Memorandum

Date: July 7th, 2017

Re: **July 11th 2017 Planning Board Workshop**
Level III Site Plan, Subdivision and Inclusionary Housing:
12 unit Condominium, One Joy Place
Onejoy Place, LLC , Applicant

SITE PLAN
SCALE: 1" = 10'-0"

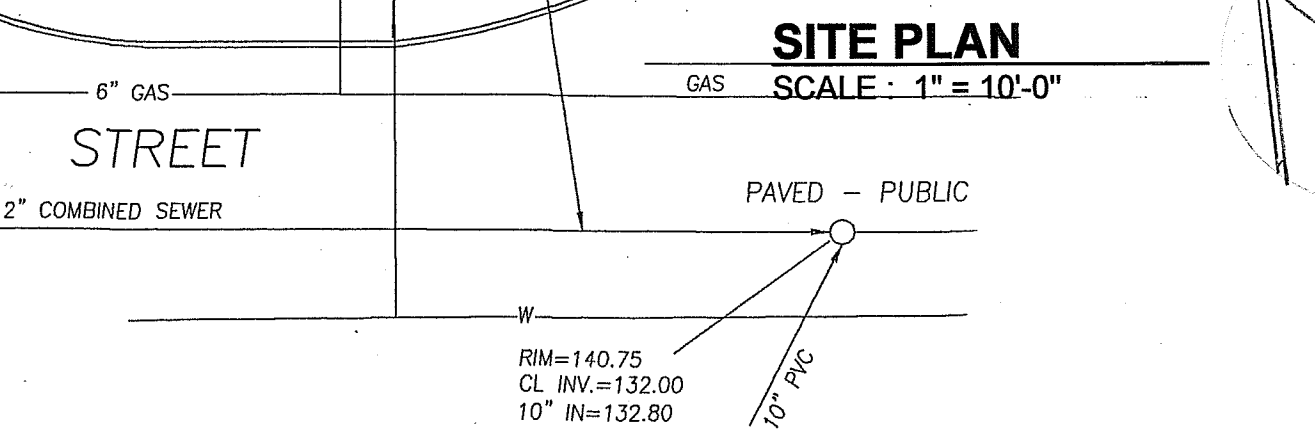
Landscaping: The proposed brick sidewalk with trees appears to be located on City of Portland land and the applicant will need to provide a license or other agreement that gives him rights to carry out this work. This amenity could be located within Joy Place if the pedestrian paved area was flush. Revisions to the proposals for the area within the narrow part of Joy Place are anticipated in order to address the neighbor concerns (167 Brackett- see PC1) and any comments from the City Arborist.

Street Trees: The project needs to include 12 street trees (one per unit) and has proposed two street trees in Joy Place to demarcate the pedestrian walkway. A revised plan is required to show the final location of the trees that takes account of the emergency service access requirements and parking provision for the existing units adjacent to Joy Place. In addition, the applicant is requested to confirm how the remaining 10 required street trees will be provided (noting the options available in the Technical Standards).
